CONSULTATION RESPONSE MATRIX

LAND EAST OF TYE LANE, WALBERTON

ON BEHALF OF: LINDEN HOMES (SOUTH) AND WATES DEVELOPMENTS

Drawing Title:
DRAINAGE CONSTRUCTION DETAILS

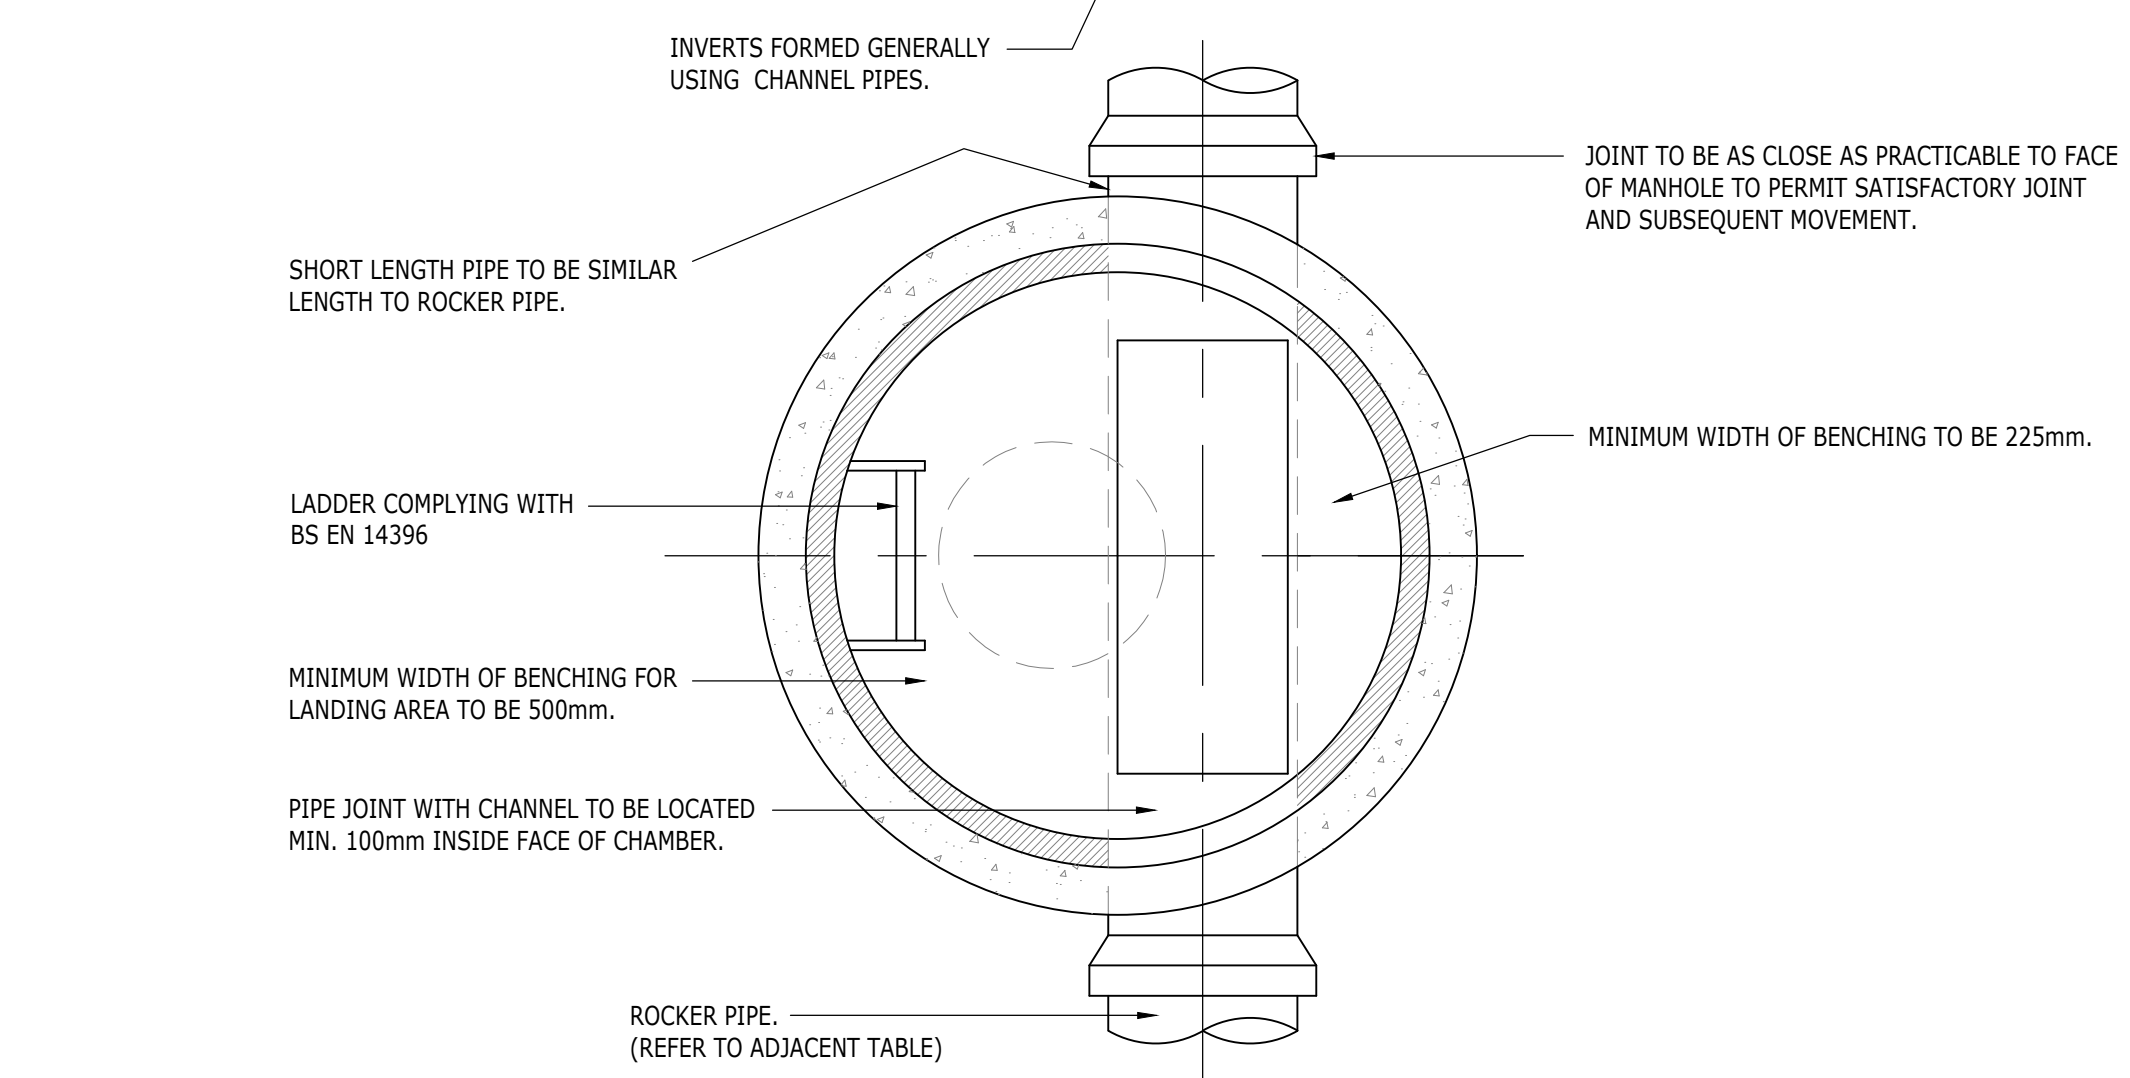
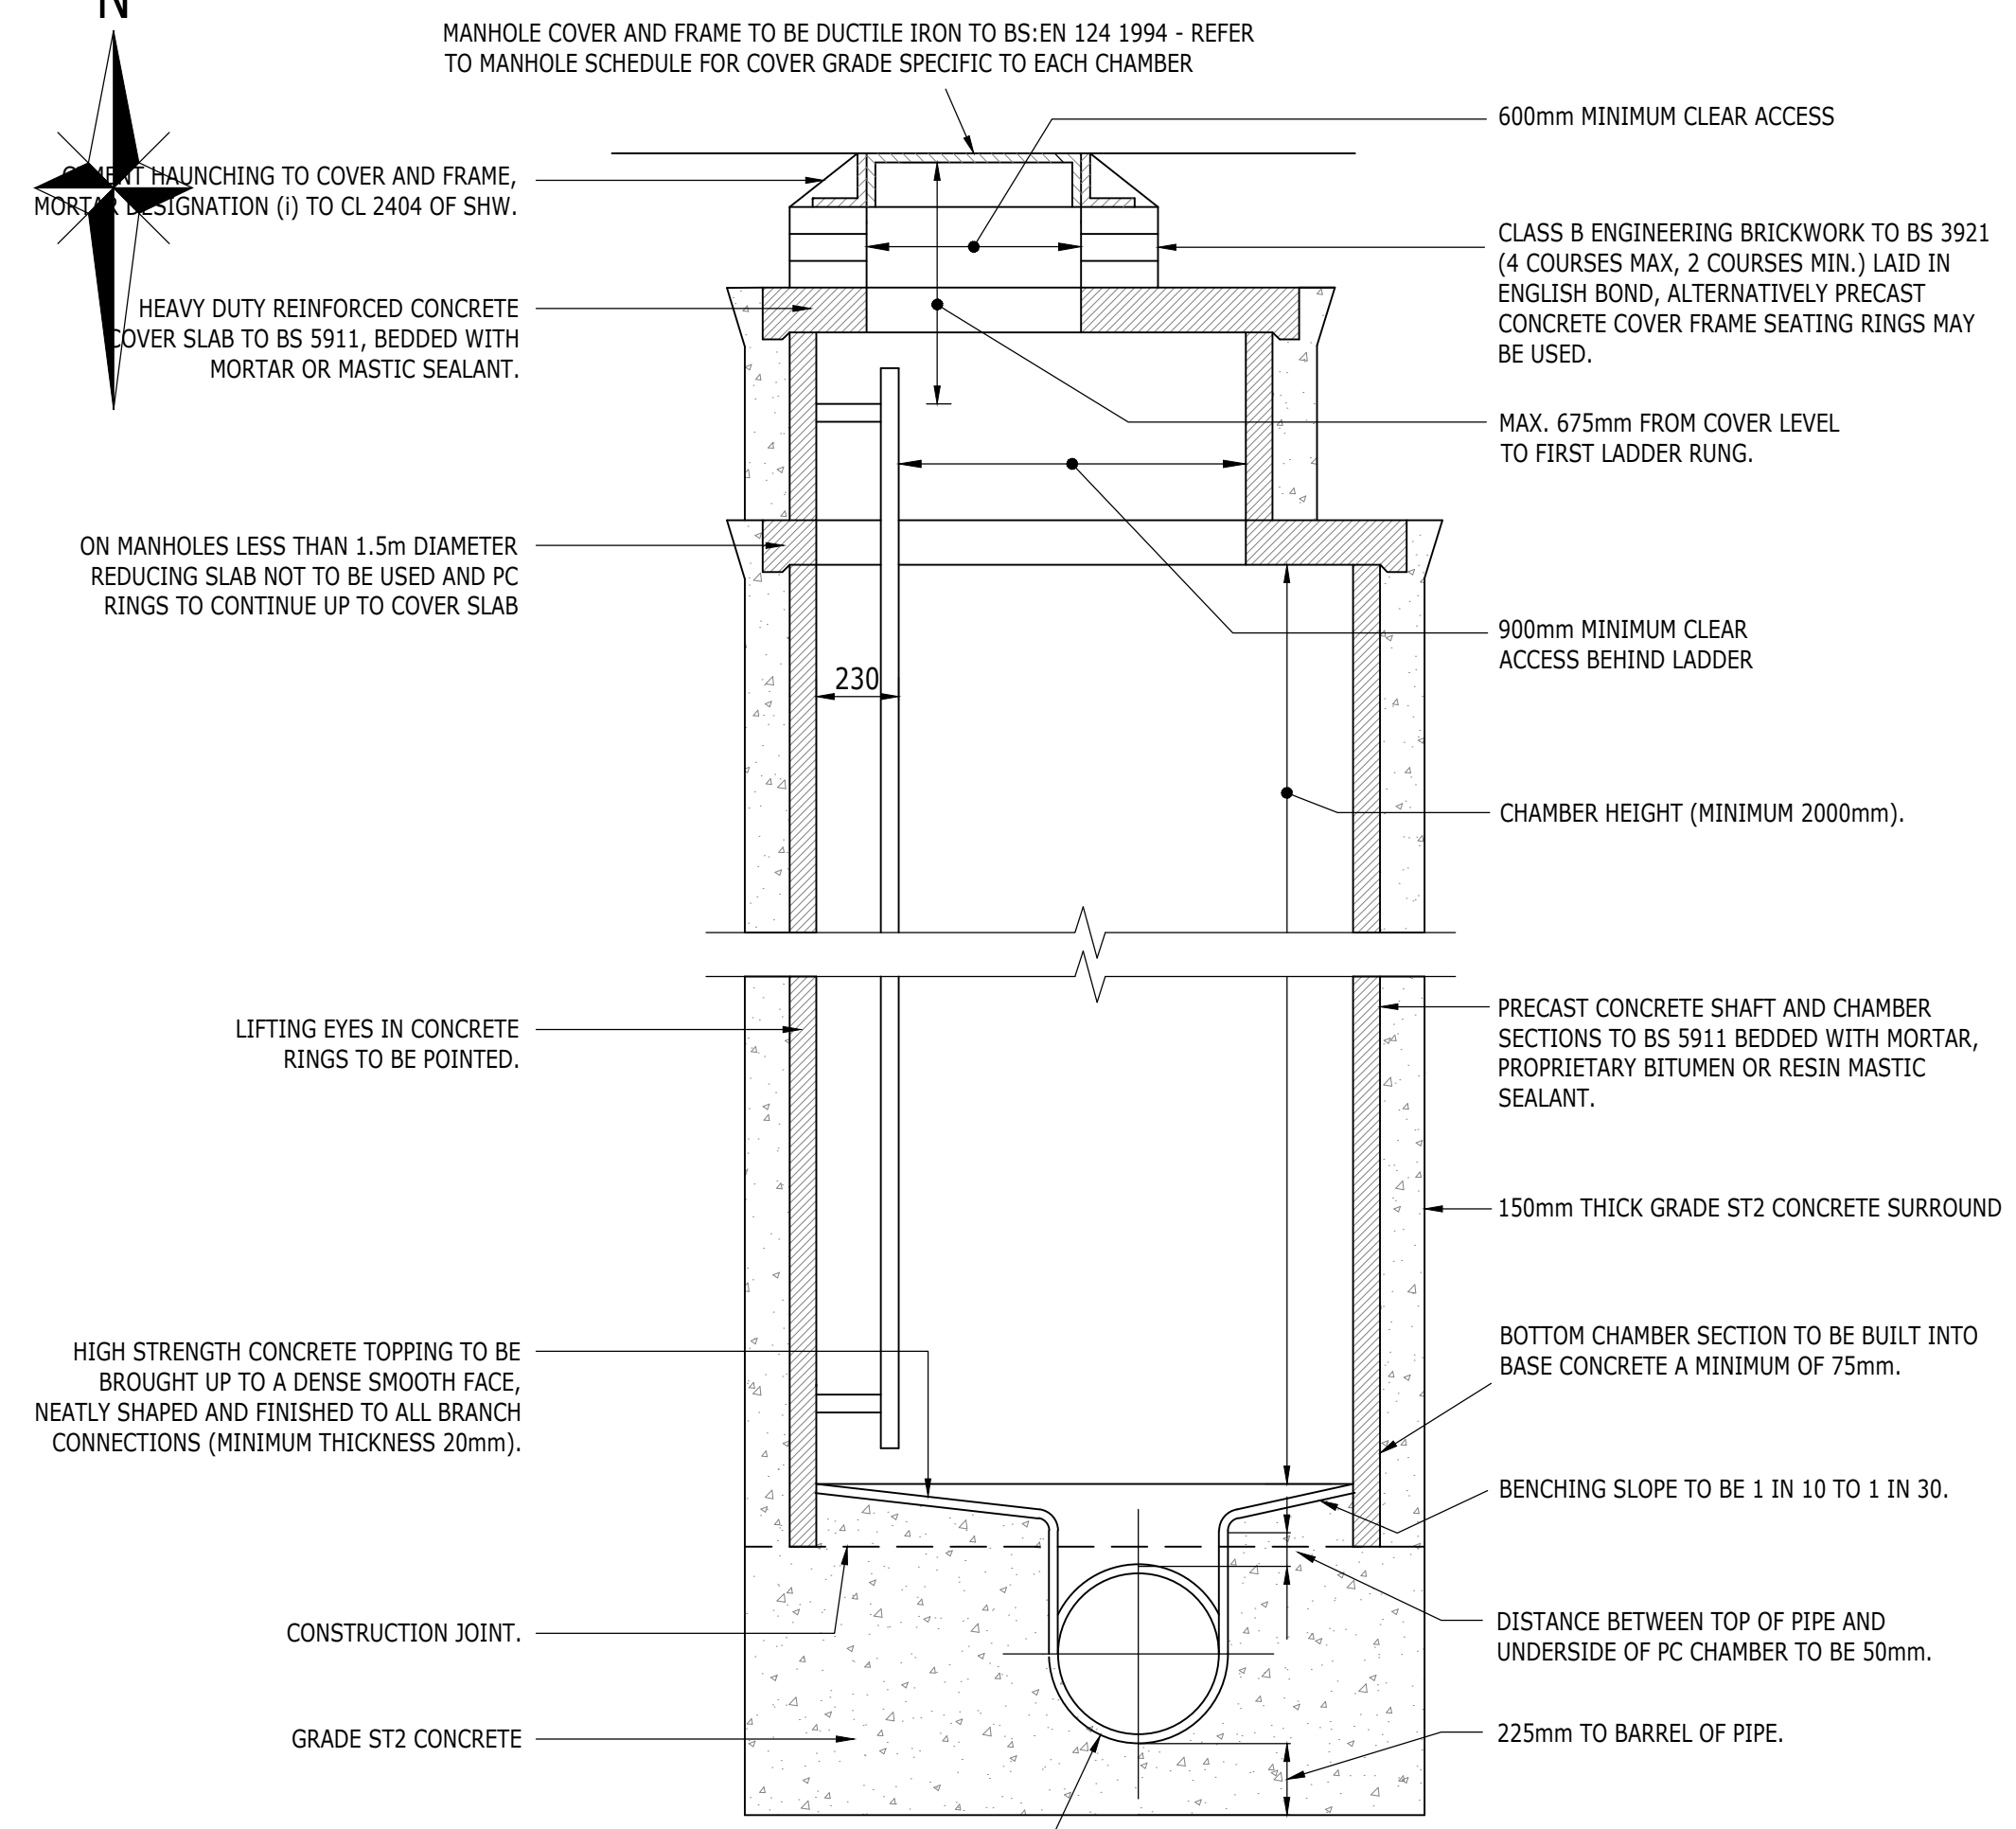
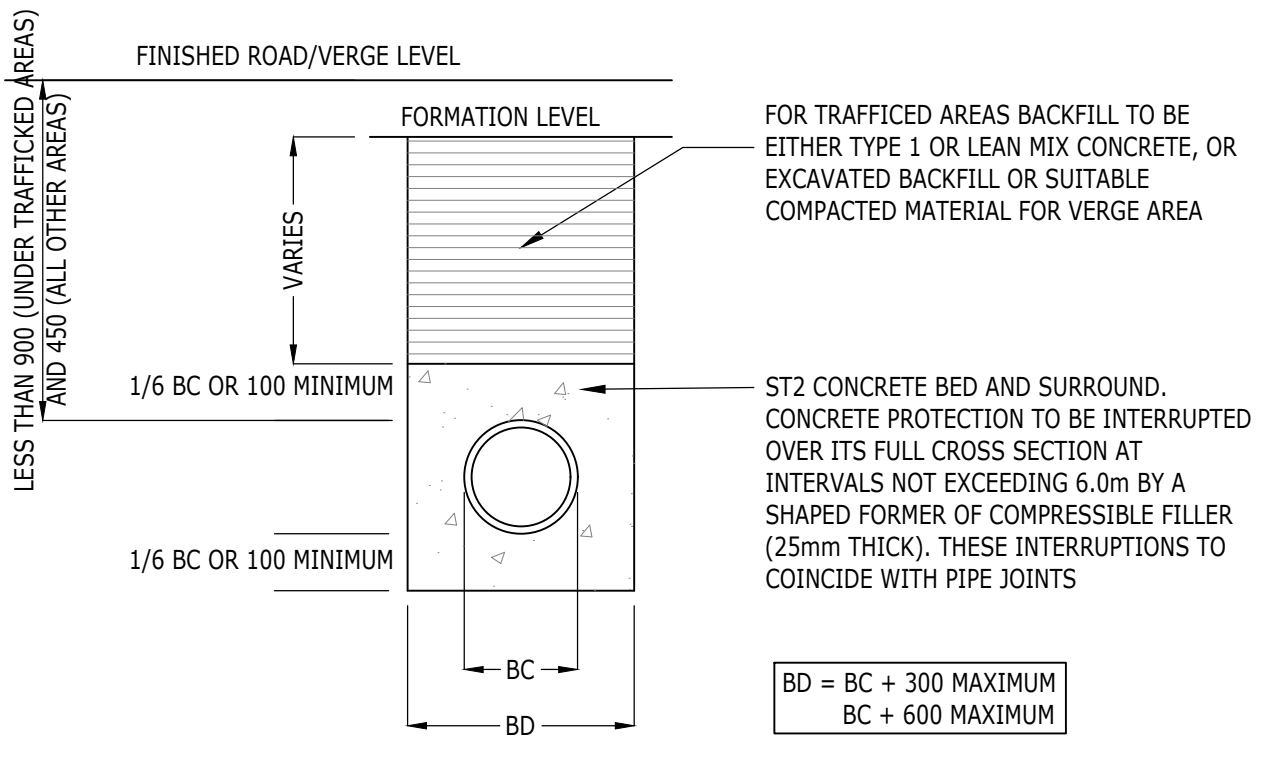
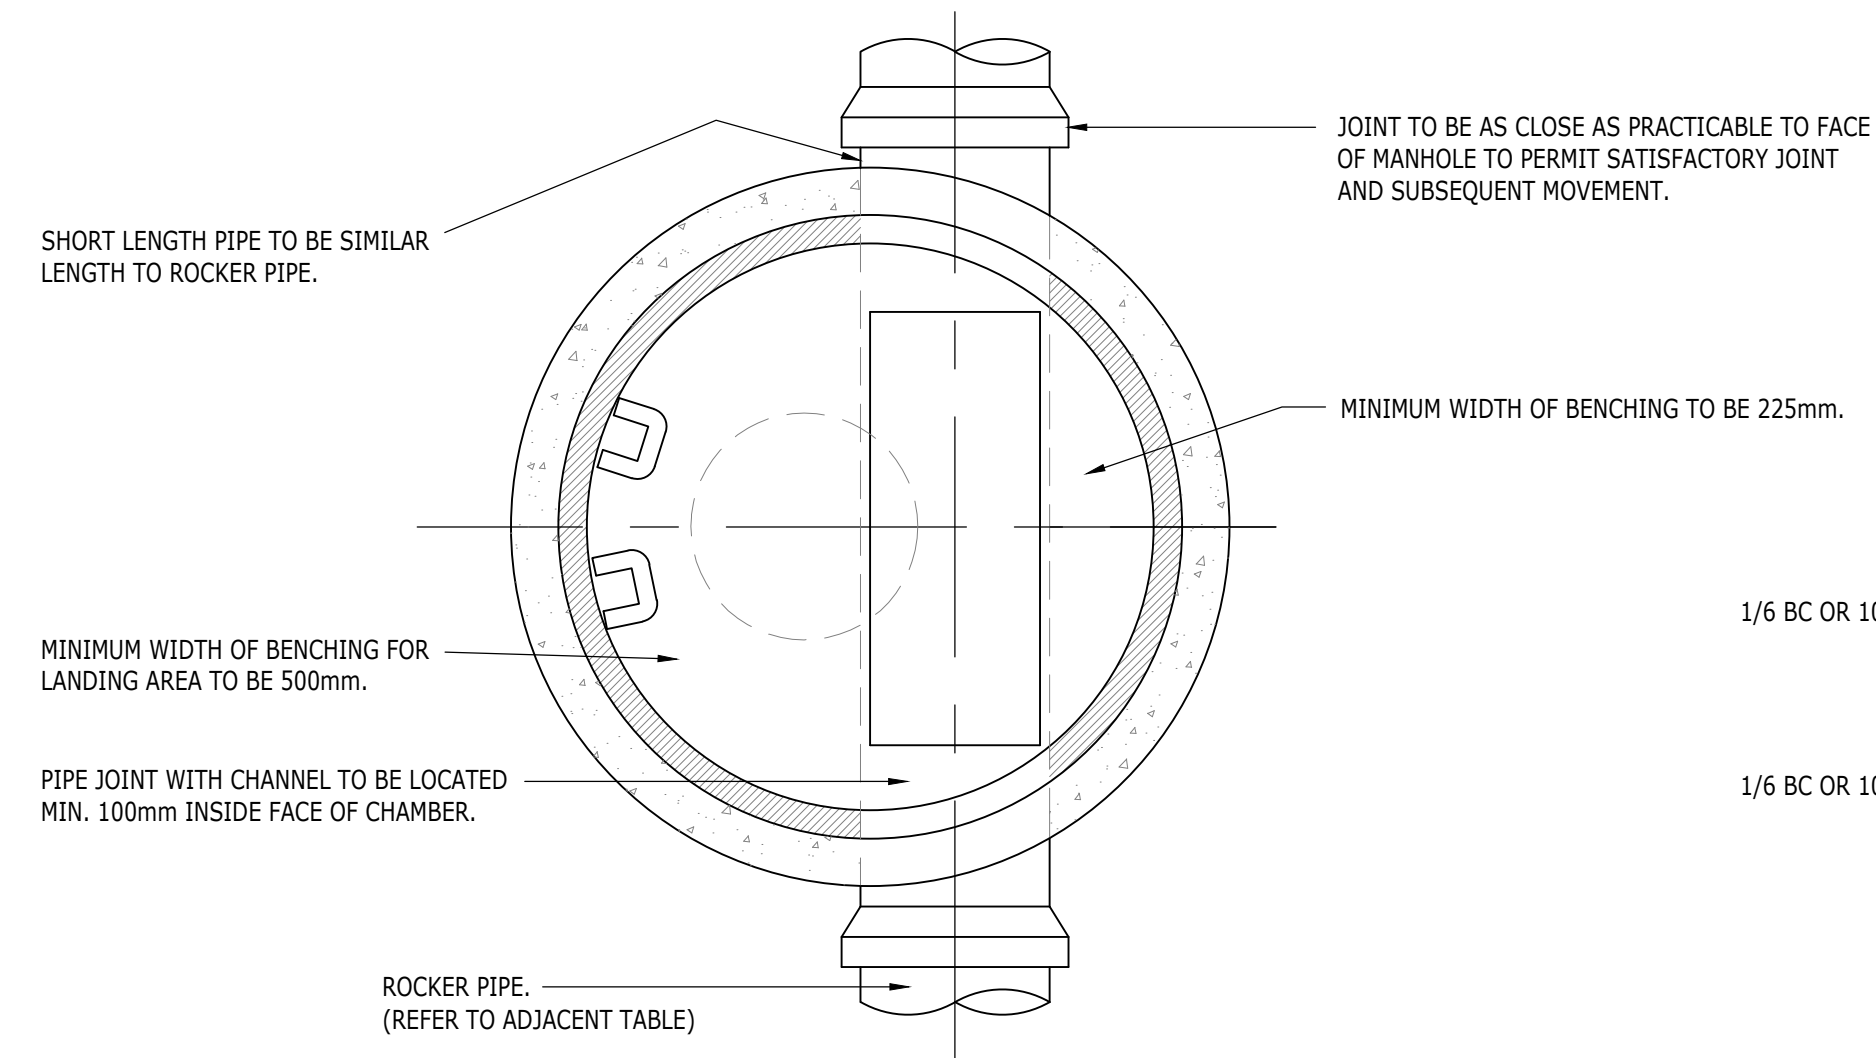
- Groundwater monitoring results and infiltration test results, including depths of testing. - Location plan showing monitoring and testing location. - Full calculations demonstrating that the 1 in 100 year plus 40% climate change event can be accommodated. - Calculations detailing that minimum half drain time requirements are met. - Safety factors are applied to design in line with CIRIA requirements Drainage layout plans, to include: - All surface water drainage pipes labelled with; diameters, falls and invert levels. - All infiltrating and attenuating structures (including permeable paving) labelled with; dimensions invert and cover levels. - All manholes labelled with; cover levels, invert levels, cover type detailed. - All silt traps clearly labelled with sump depths. - Control structures with outflow rates and invert levels. - Construction detail drawing, to include (if specified in scheme): - pipe bed and surround - Infiltrating structures - Manholes - Catchpits/silt traps - Control devices - Permeable paving - Headwalls - Exceedance flow routes	Available, including for the winter months as requested. These are submitted with the revised pack. As above. We have carried out full hydraulic calcs and these will be submitted. They demonstrate that the above storm is accommodated within the system with no flooding. These are included in revised details and the figures are well within the required parameters. As standard, we have carried out our design with a safety factor of 2 which adheres to the above as there is no damage or inconvenience, i.e. the water does not flood from the basins. This is as per the current drainage plan, no update required. The revised plan have added the areas of each porous paving construction and also add a typical detail (to detail the depth) for said porous paving to the General Arrangement Plan. Plans now note that "all cover types are to be a suitable load class for their proposed loading". Key added to the plan that all highway and private swale network manholes are to be catchpits with a 300mm sump below IL. Added to the plan the controls with levels and sizes (orifice plates). as per sewers for adoption. as per detail already on drawing. as per sewers for adoption. as per local highway authority details. Added a typical orifice plate detail. as per typical detail added to General Arrangement Plan as per sewers for adoption. Added to plans
